Waddington Parish Council

14 July 2026

Ref: Planning application 3/2026/00381 – Proposed two-storey side extension, single-storey rear extension, alterations to roof to accommodate an additional storey, material alterations to the facades and a new relocated site entrance – Hunters Gate West Bradford Road Waddington BB7 3JE

A2.2

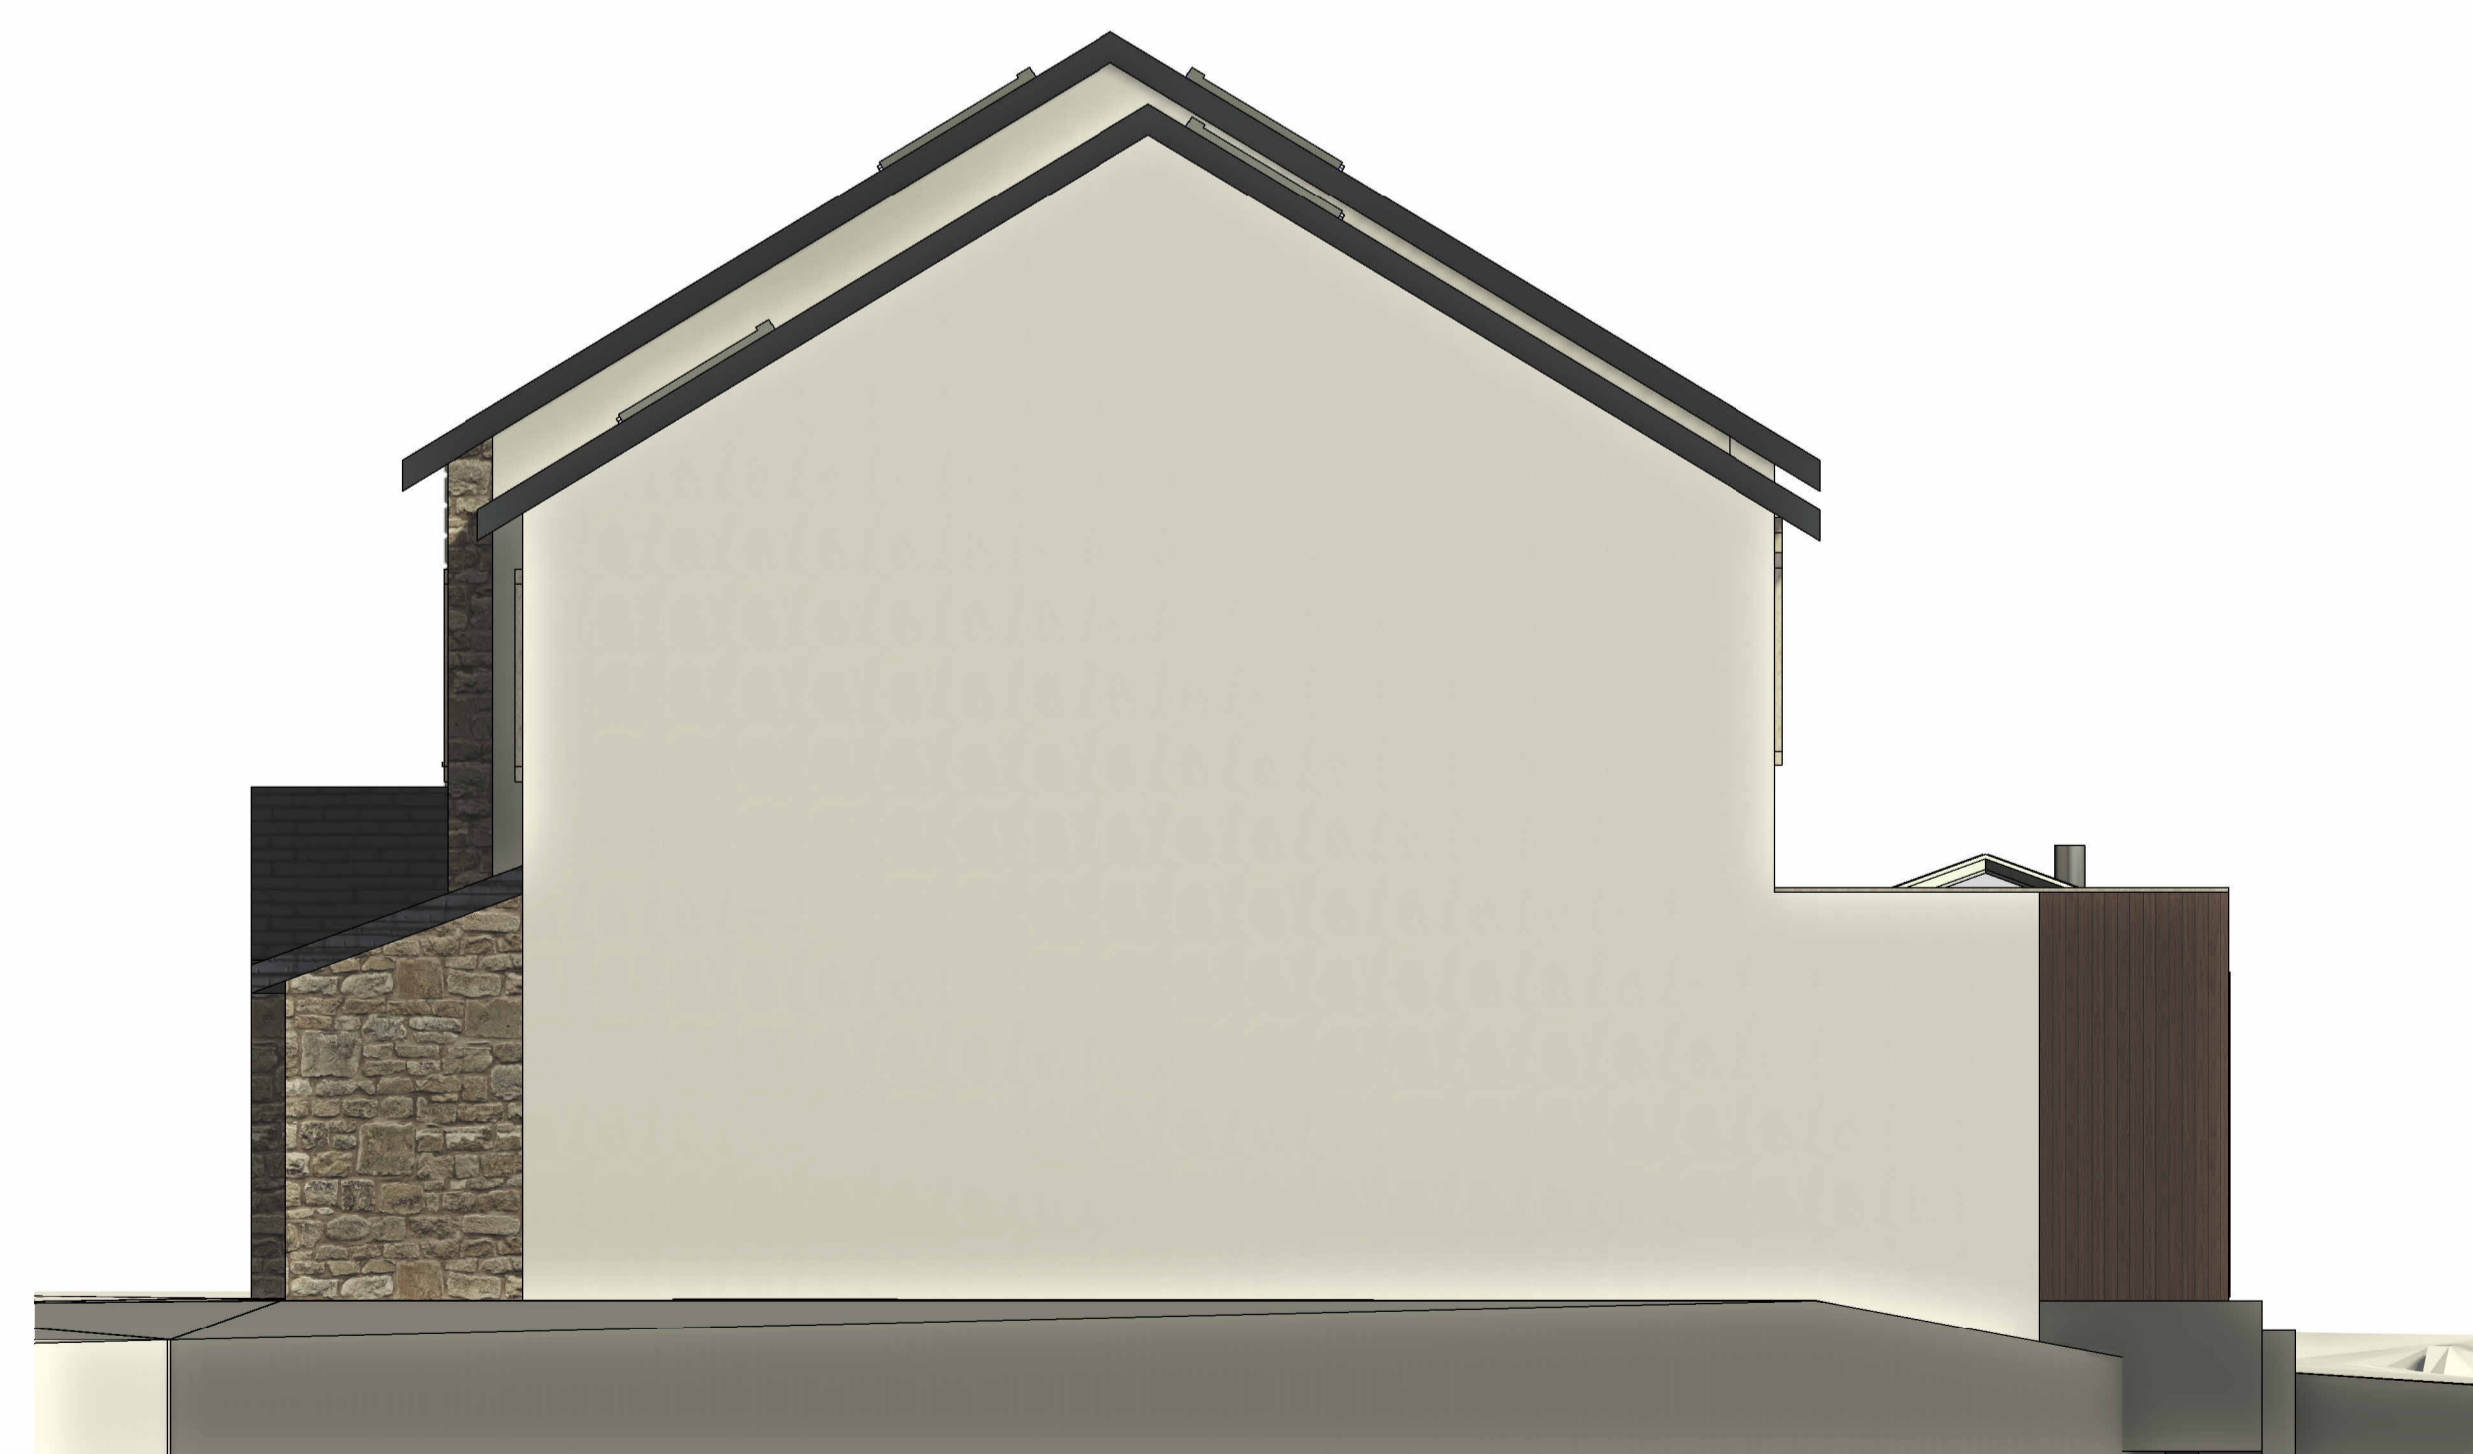
The Parish Council recommends that at least two integral swift nesting bricks (or other suitable integral bird nesting features) are incorporated into the new extension at eaves level, together with consideration of bat roosting features where appropriate. Swift bricks should be positioned at least 5 metres above ground level with a clear flight path and retained for the lifetime of the development.
